Our ref: XA/2024/100121/05-L01
Your ref: EN010122

**EXAMINATION - OAKLANDS FARM SOLAR DEADLINE 6 (26 NOVEMBER 2024)
- EA RESPONSE TO EXQ3. OAKLANDS FARM SOLAR PARK, DERBYSHIRE.**

Figure 4.12: Watercourse crossing

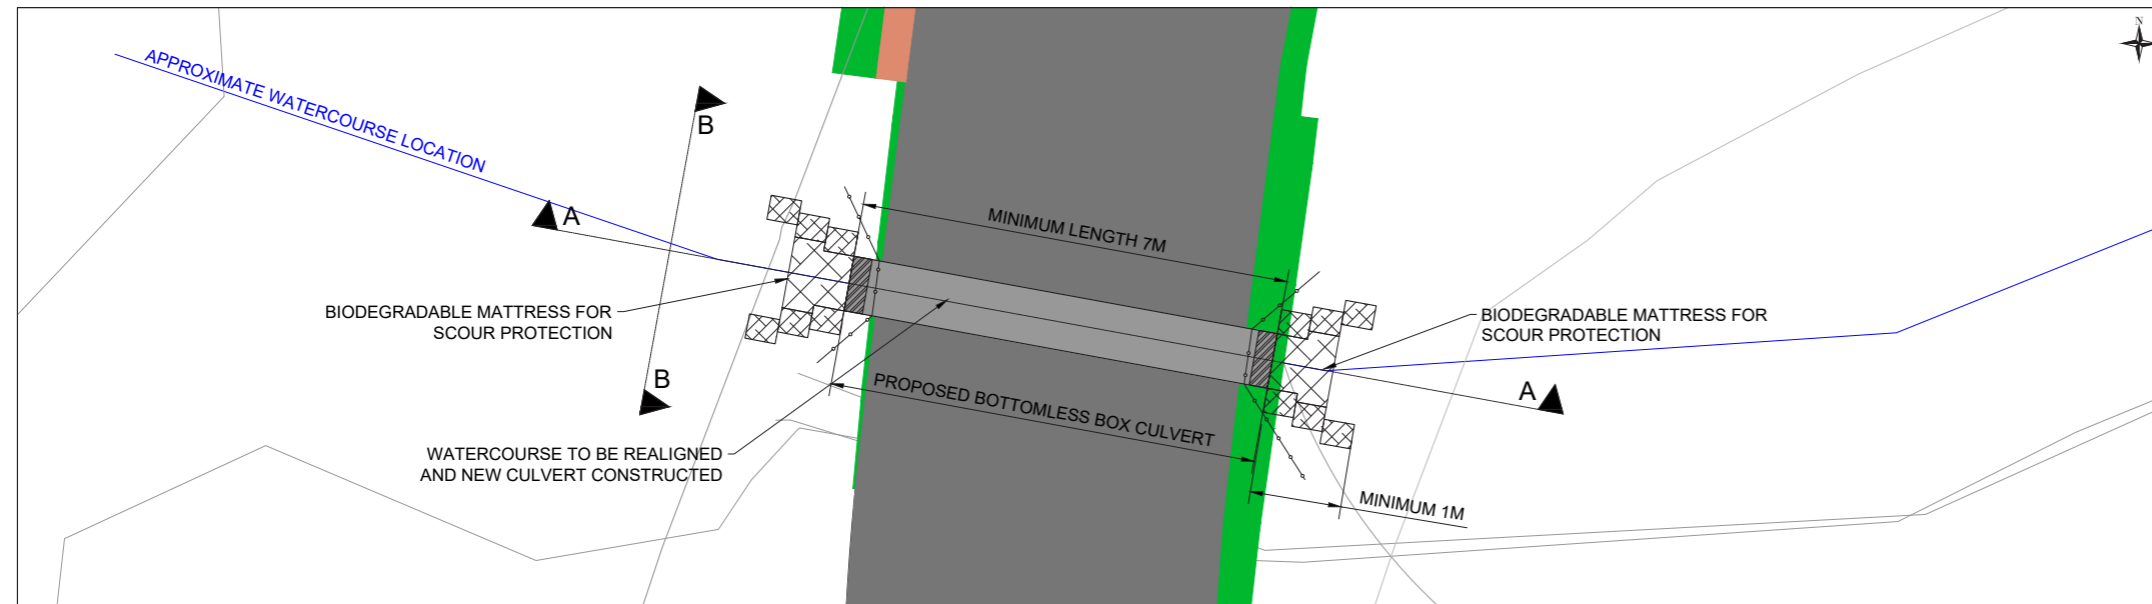
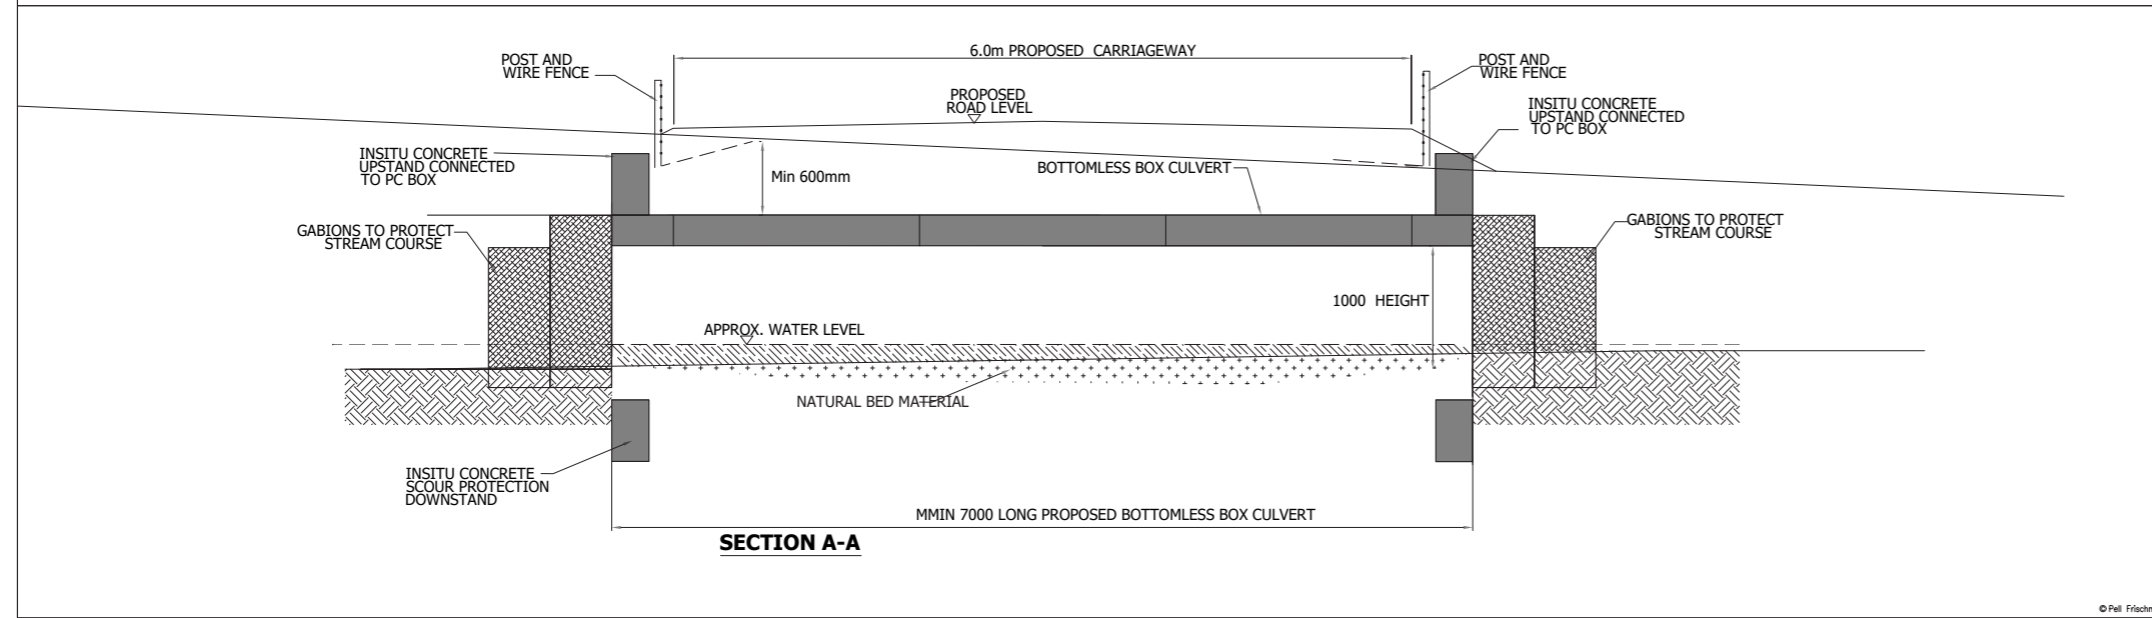
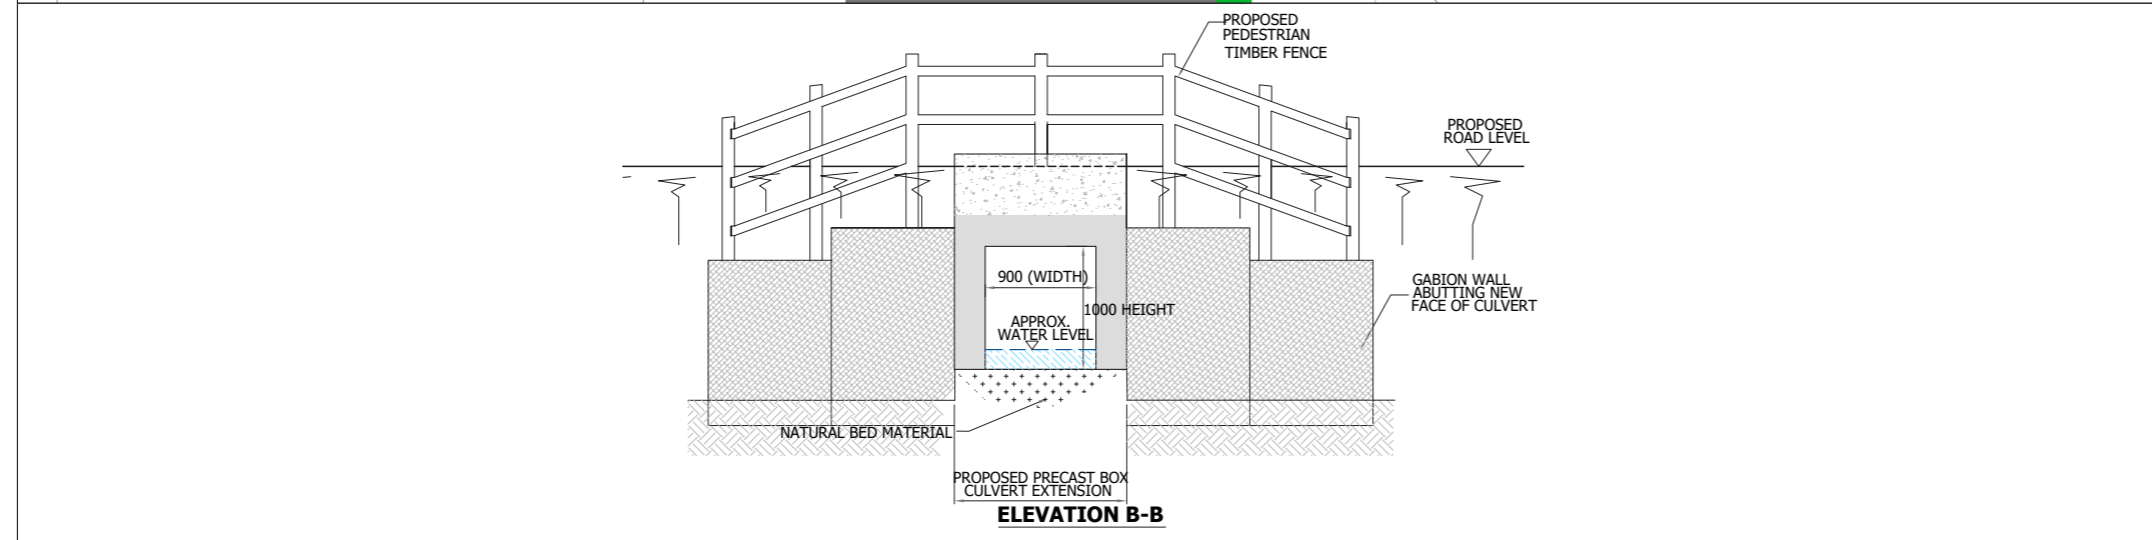
The Applicant’s modelling has shown that implementing new watercourse crossings (culvert structures) causes increased flood risk off site to depth of up to 15cm. This is against government policy NPS EN-1 as there must not be an increase in offsite flood risk to pass the Exception Test.

The removal of the culverts for the operational phase seems like a reasonable way forward to address the off-site increase in fluvial flood risk. However, there is still a

risk that flood risk could be increased off-site during construction if an event were to occur.

Following a meeting with the Applicant's consultants on 26 November 2024 they have proposed to install a temporary clear span bridge structure (instead of a culvert) at crossing 3, which is the crossing that causes the offsite increase. This will likely remove the offsite flood increase. We are awaiting updated model runs which include the clear span structure to determine the appropriateness of this approach. We will provide the Examining Authority with an update at Deadline 7.
